Important written representations on behalf of a landowner affected by two proposed substations and associated cable routes within their farm property

**WRITTEN REPRESENTATION FOR DEADLINE 1 – 20 MAY 2025**

**PLANNING INSPECTORATE REFERENCE NUMBER: EN020028**

**MADE ON BEHALF OF HORNBIES FOUNDATION CHARITY 503802**

Figure 1.4: Indicative areas of habitat creation and enhancement at the Morgan onshore substation

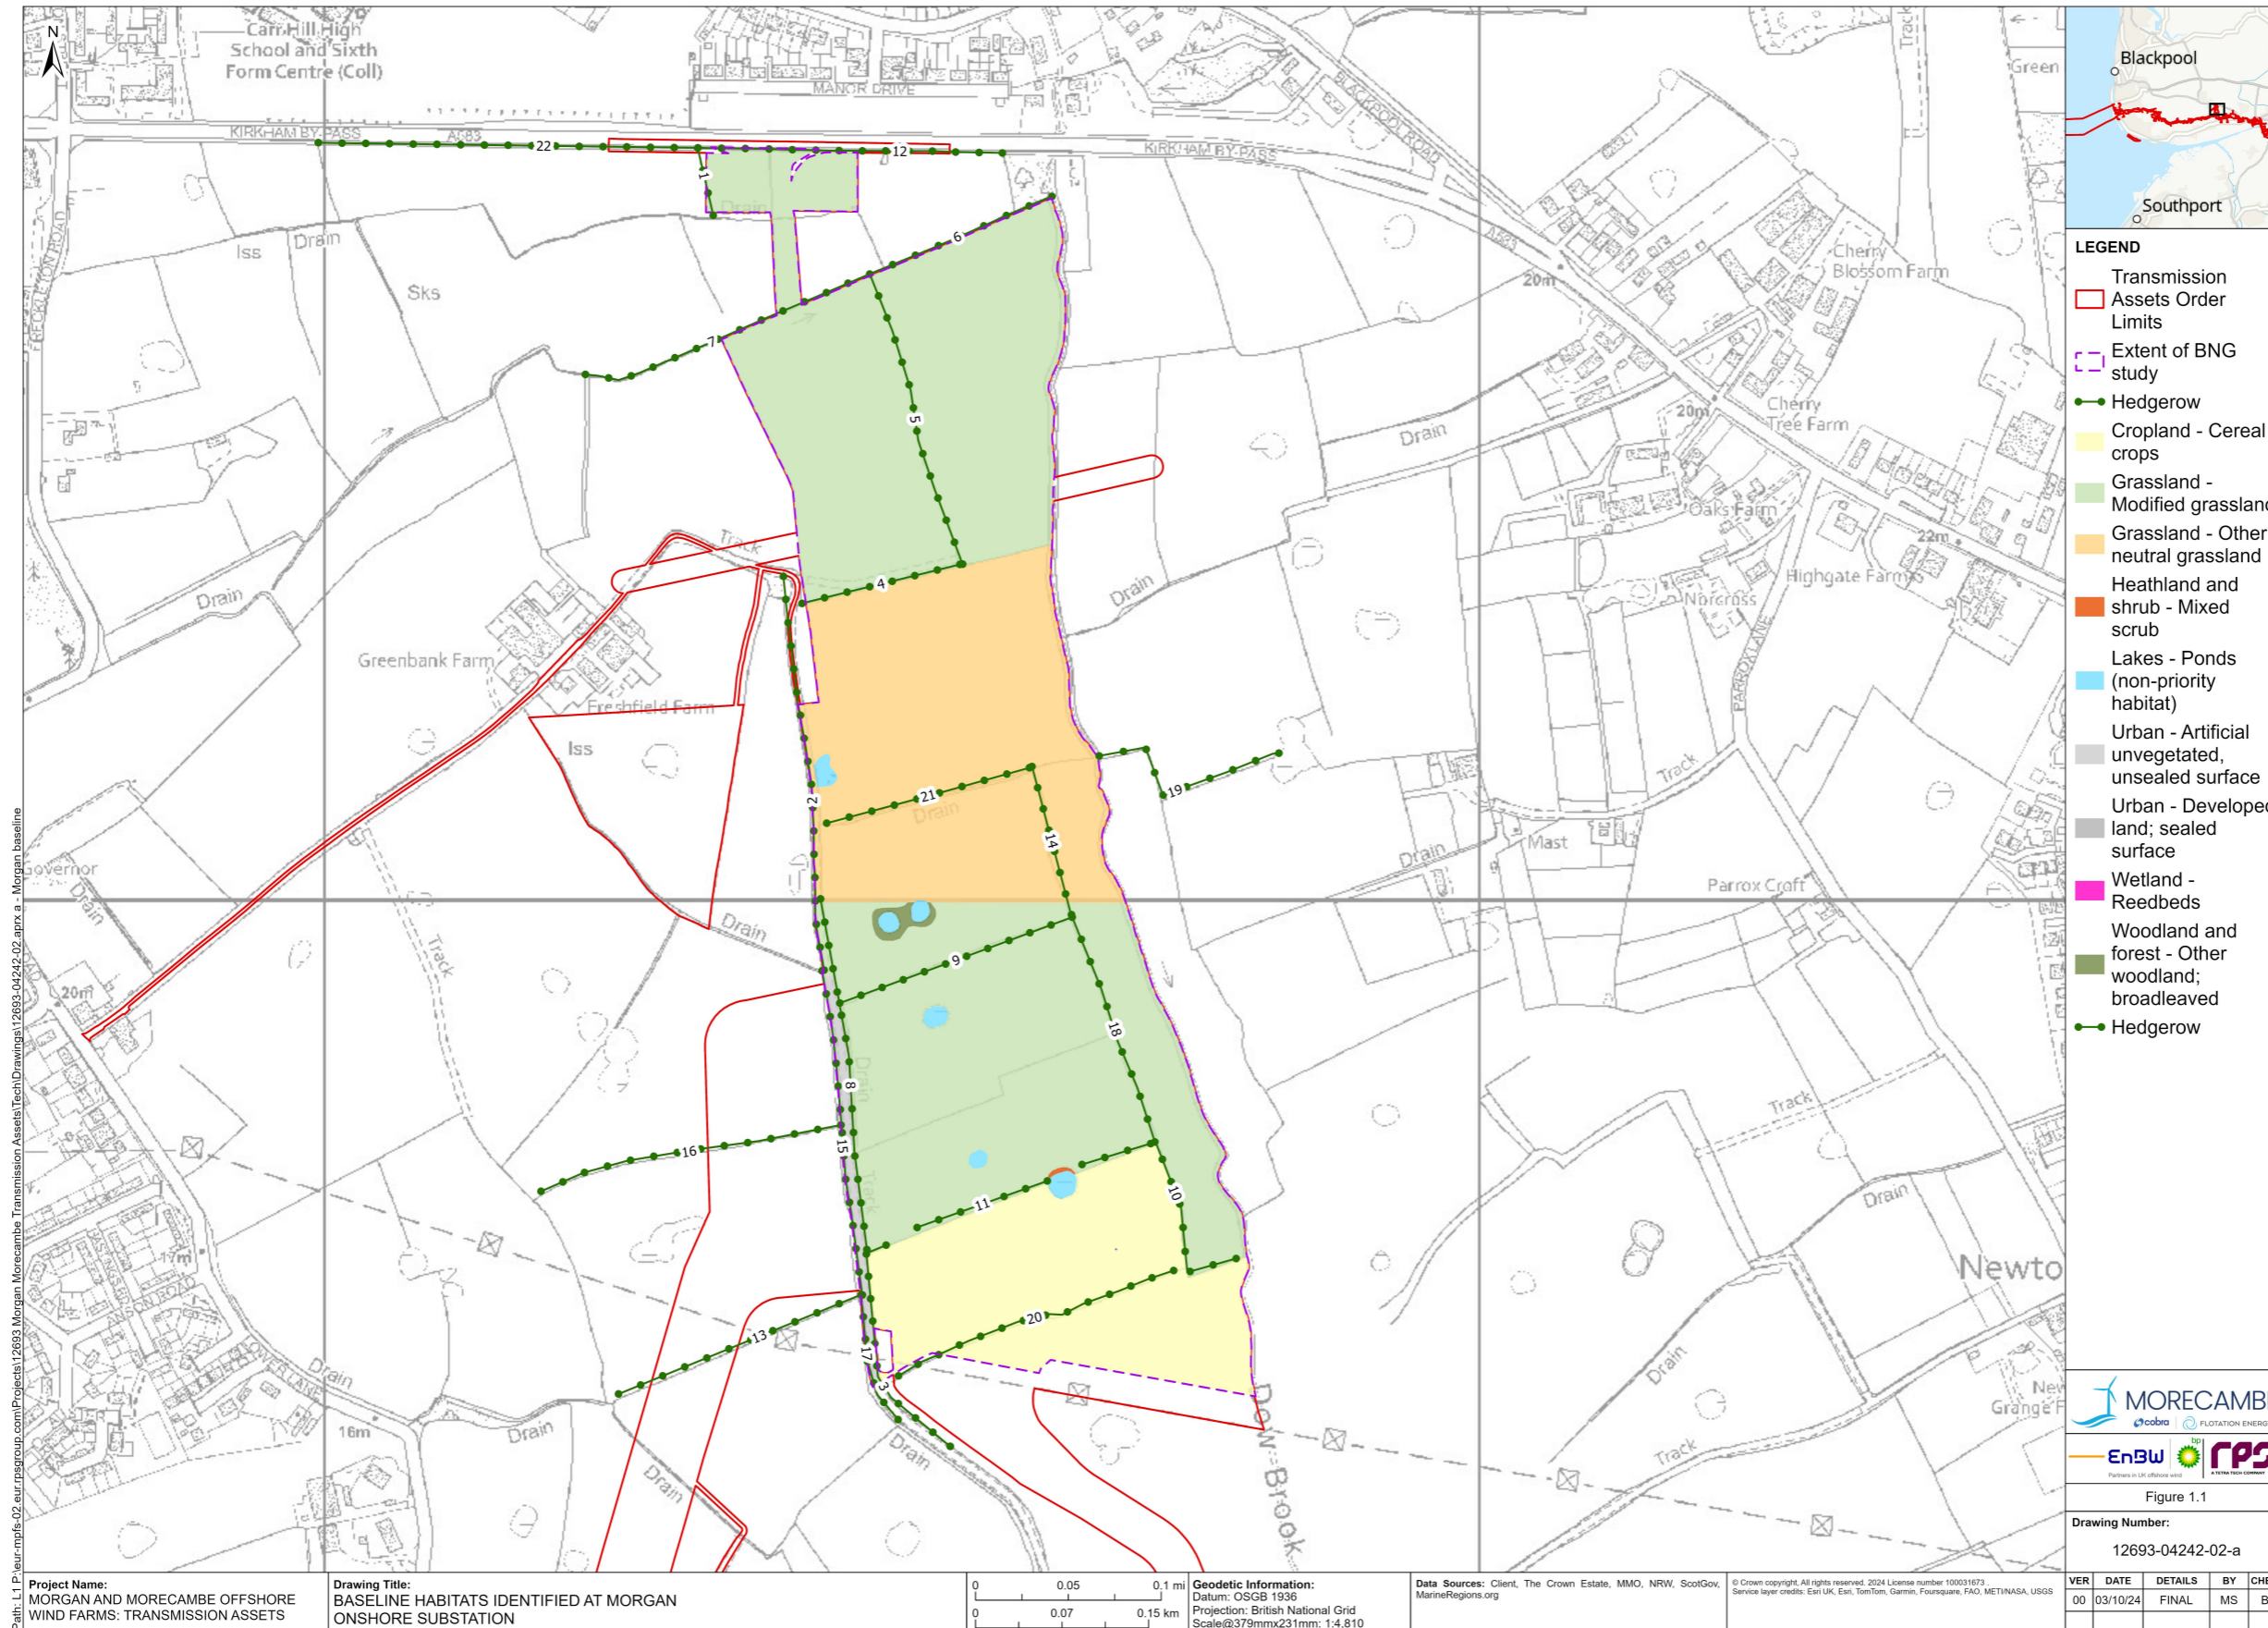
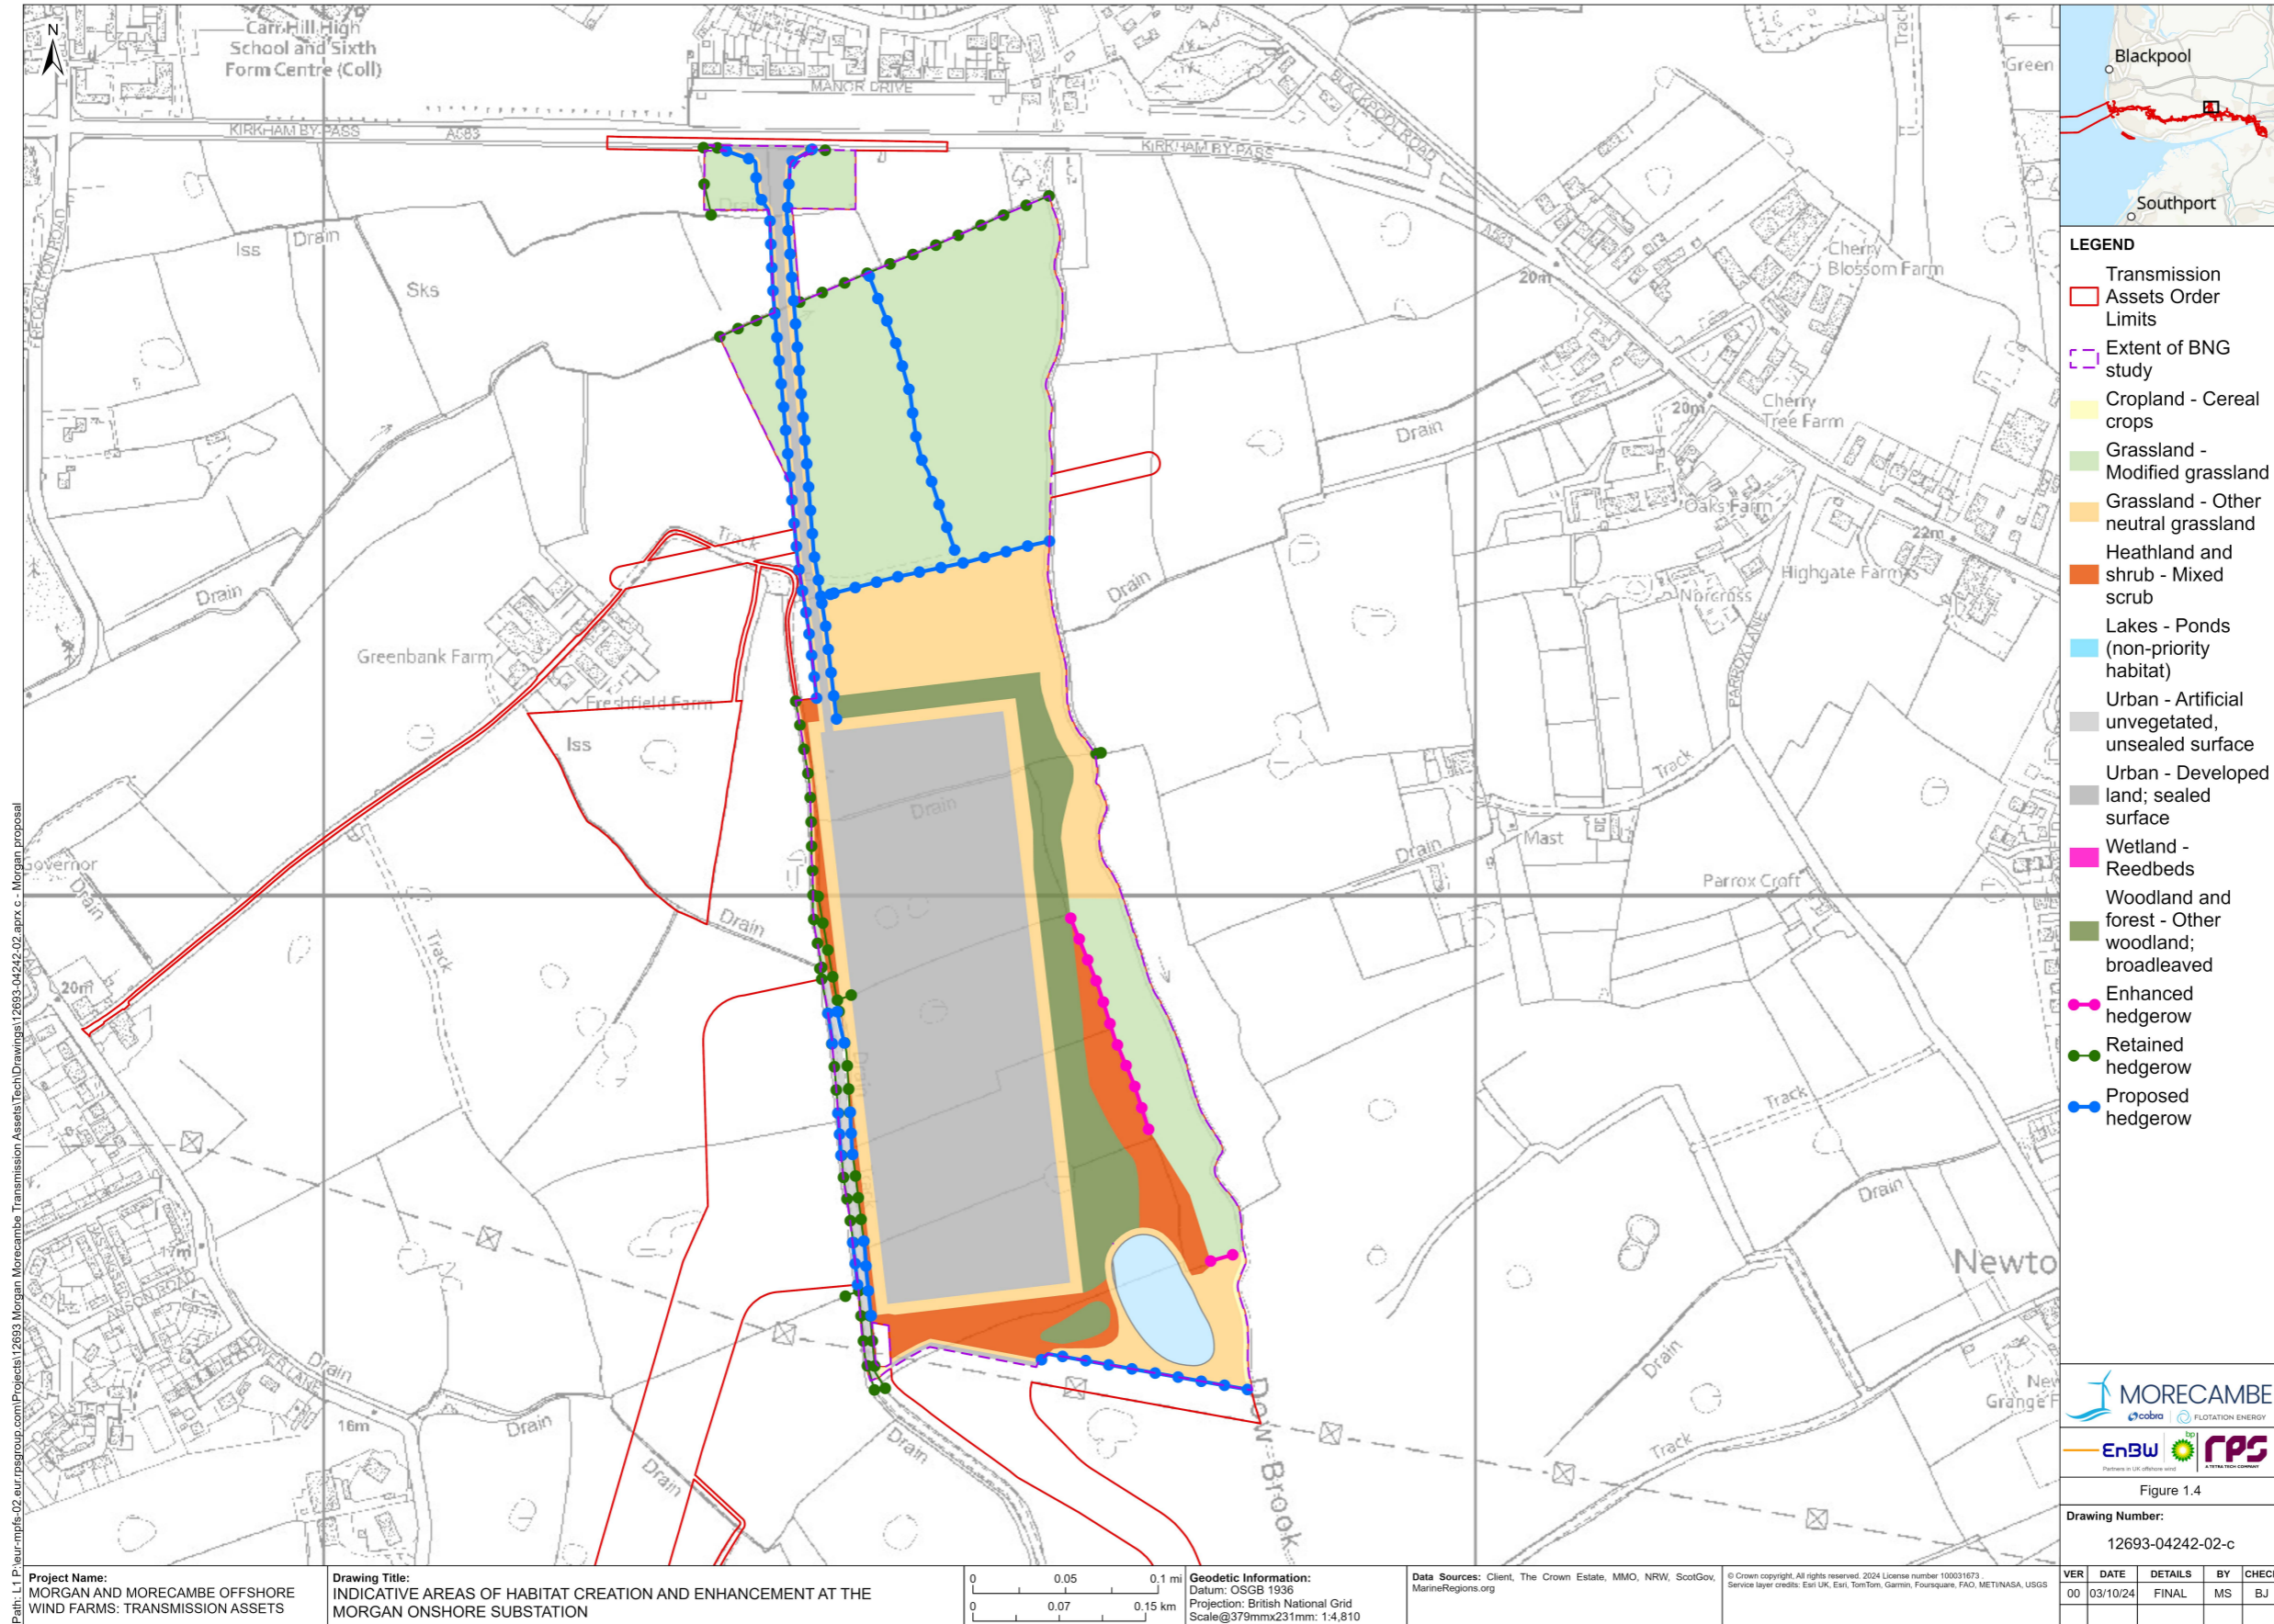
**Table 4.6: Onshore Substations infrastructure parameters for site selection (PEIR) advises maximum site footprints of Morgan 12.5 Ha and Morecambe 6.0 Ha, however Morgan have taken land beyond SI Works 21A up to Dow Brook for mitigation purposes as acknowledged at Selection of Morgan OWL and Morecambe OWL Onshore Substations (Environmental Statement Volume 1, Annex 4.3: 4.5.5.19)**
